From: Roger Spencer <Roger.Spencer@arun.gov.uk>
Sent: 29 March 2022 12:07
To: Michael Eastham <Michael.Eastham@arun.gov.uk>
Cc: Paul Cann <Paul.Cann@arun.gov.uk>
Subject: RE: Dappers Lane, Angmering (A/188/21/DOC)

Subject: Dappers Lane, Angmering (A/188/21/DOC)

I confirm that I have no objection to Condition 17 (Levels).

I would also confirm that outstanding issues with Condition 18 (surface water drainage) have been satisfactorily resolved and accordingly this can be signed off.

Longitudinal Sections & MH Schedule Plan

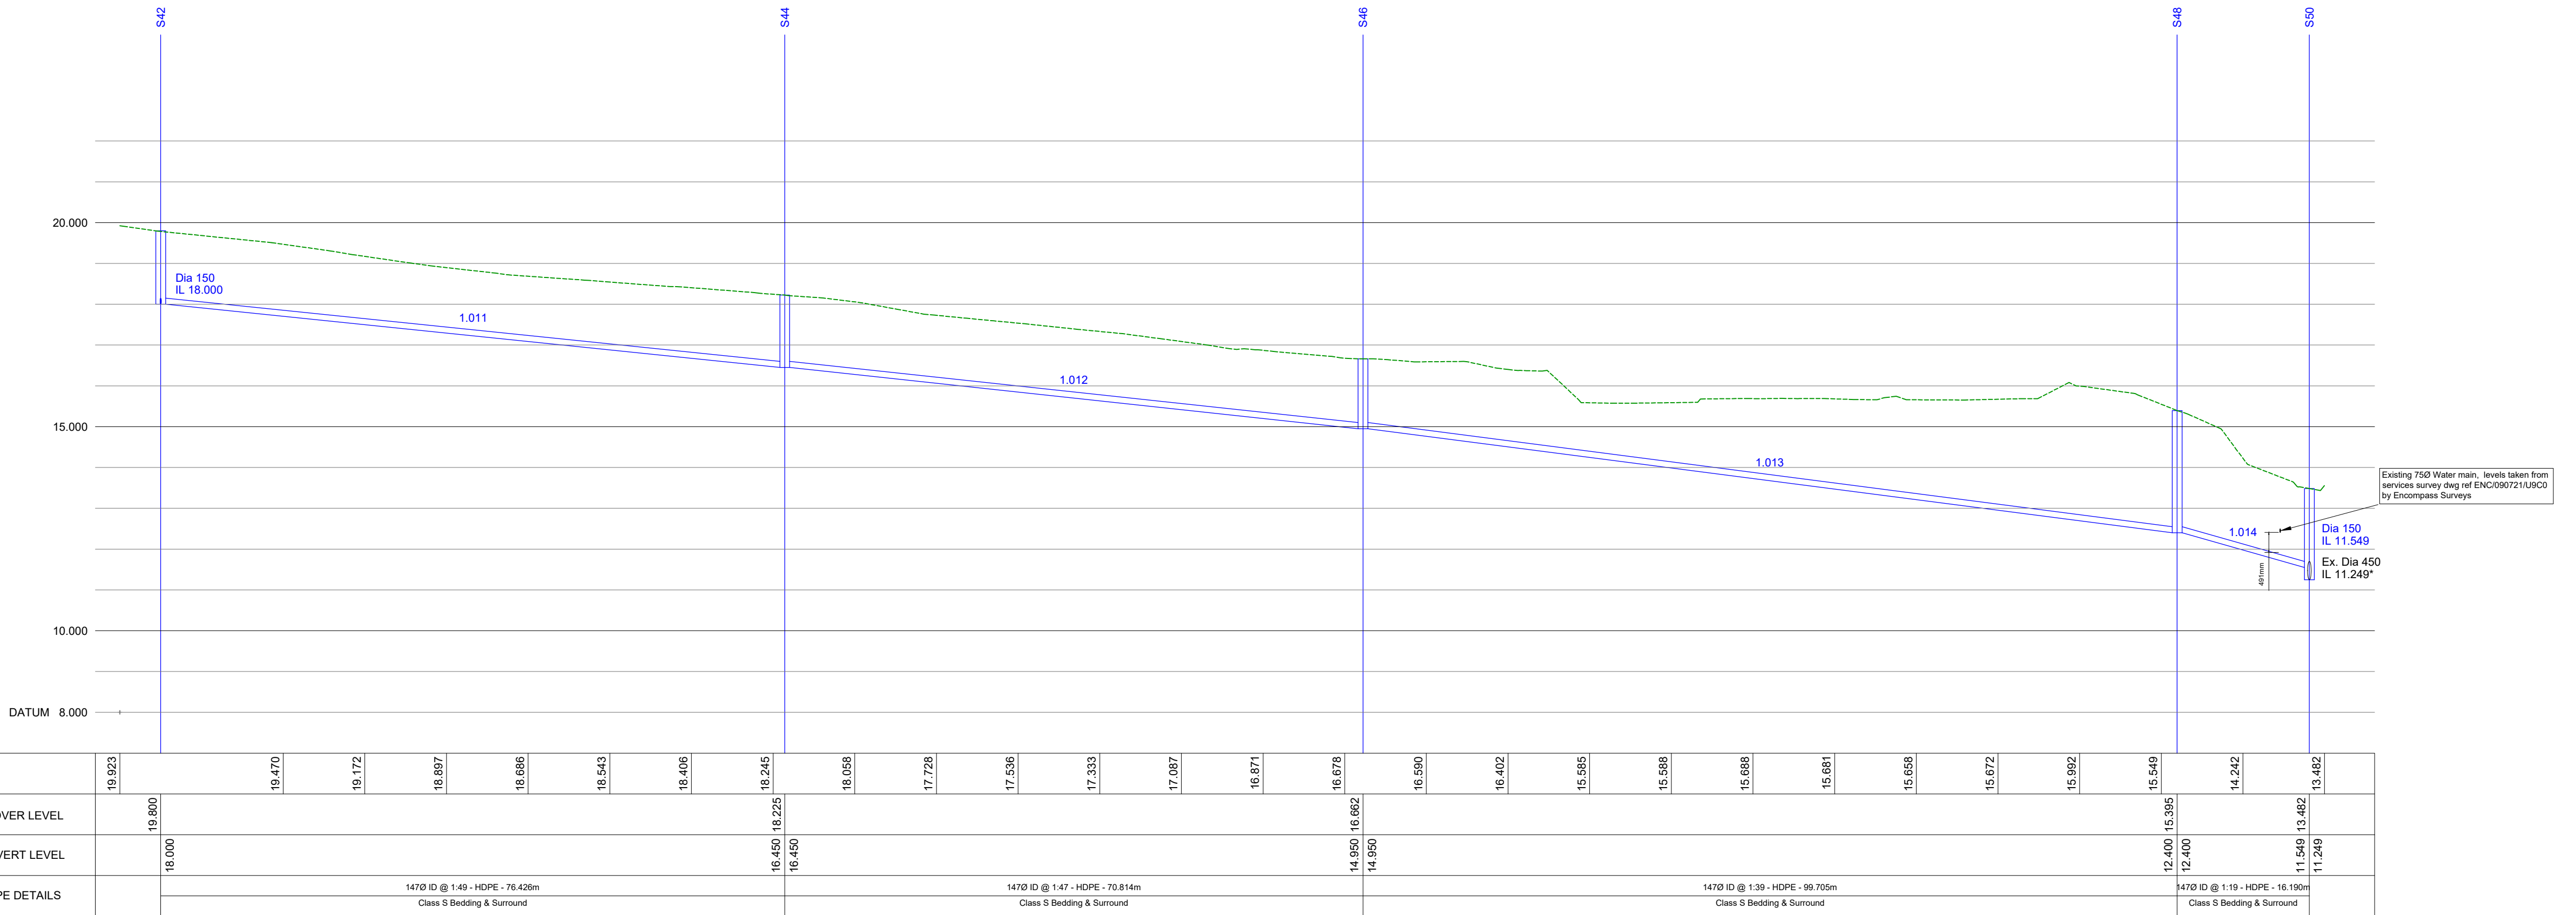
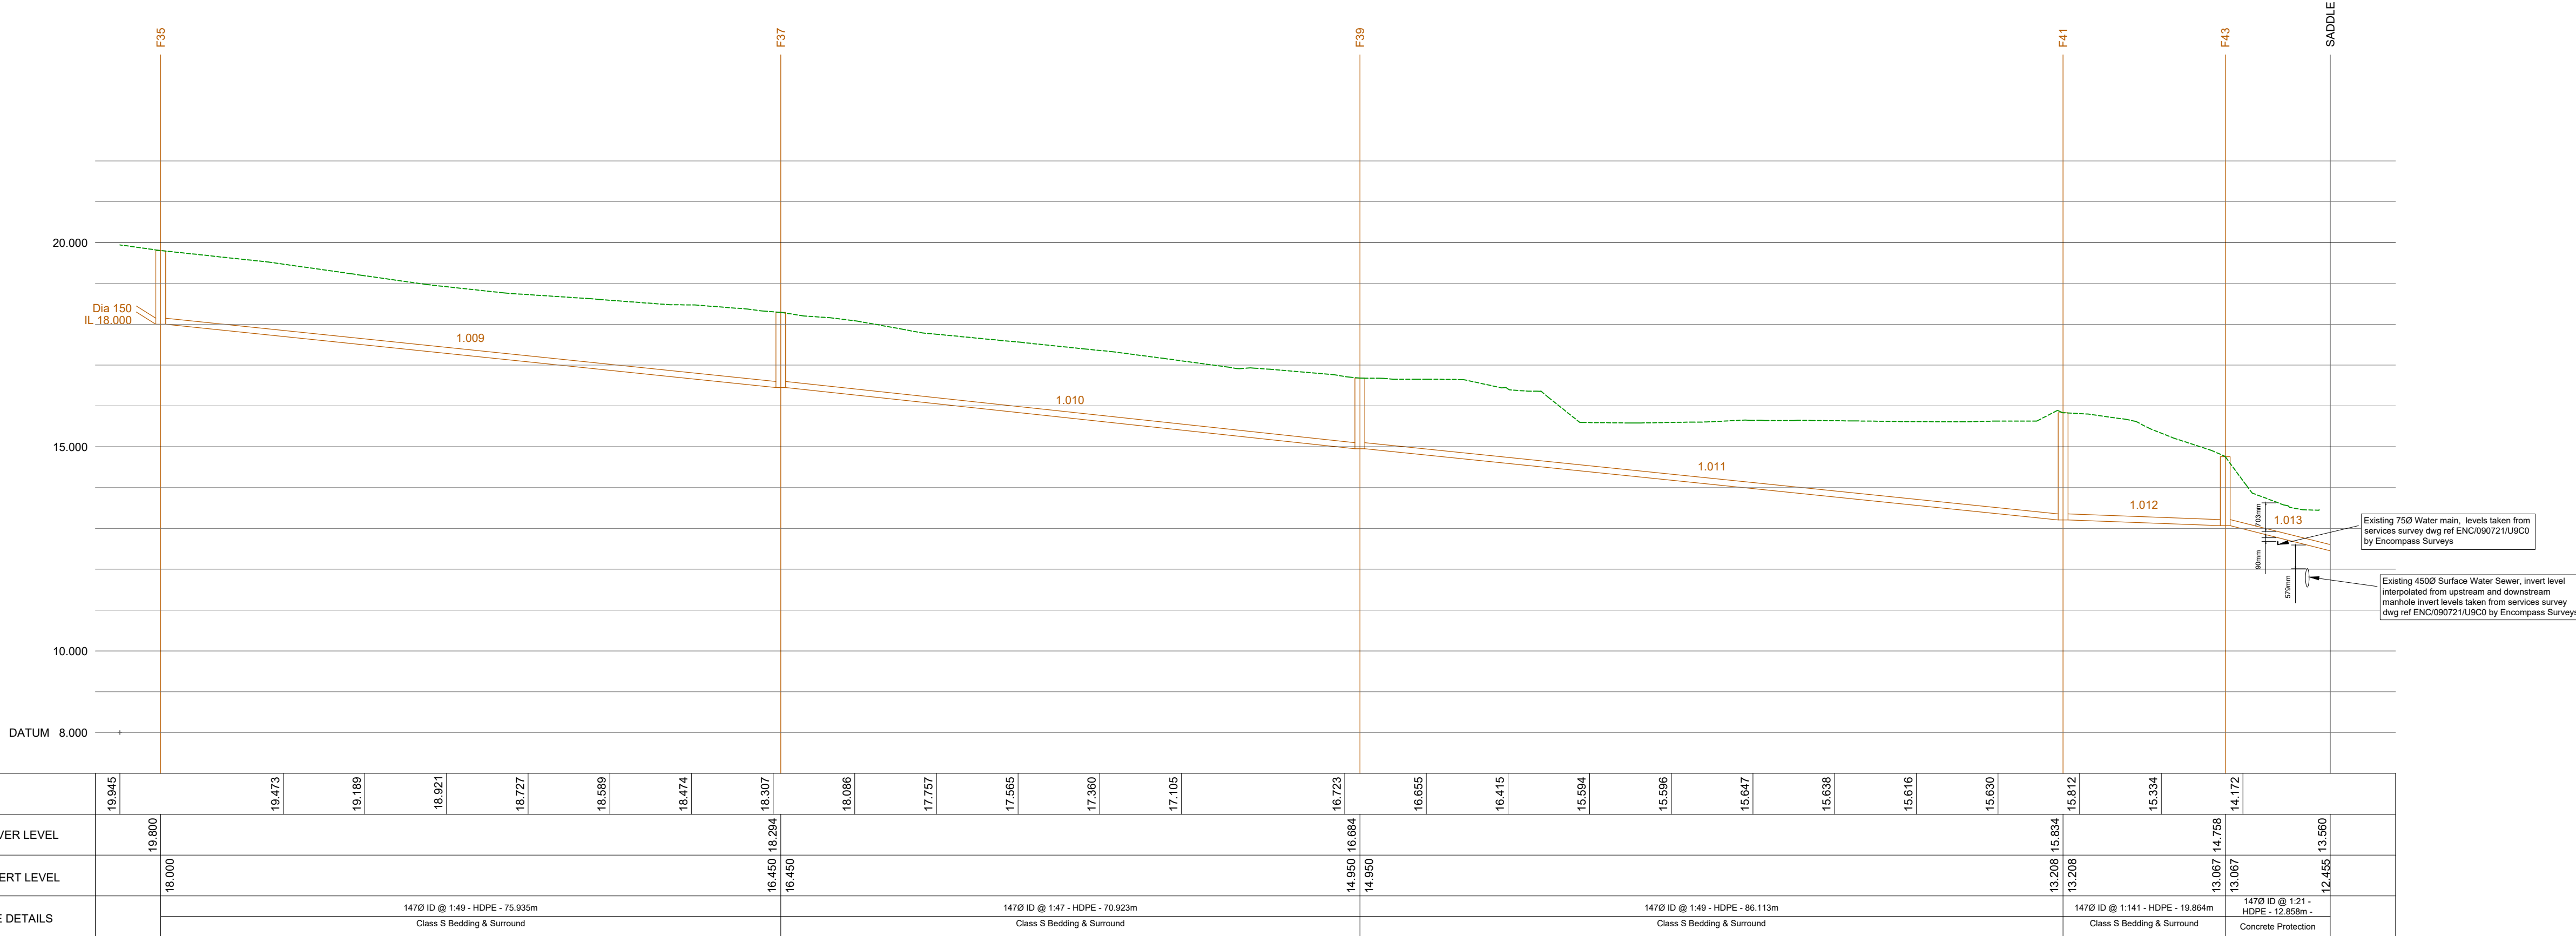
Conditions 21 (Discharge of flows) & 22 (Foul Drainage) – there is lack of clarity around the actual points of connection in Arundel Road. The connections were made by DTCivils with the Client ICOSA (requisitioned by Persimmon) for dealing with the Persimmon site flows. We are working with Persimmon and ICOSA to resolve the issue.
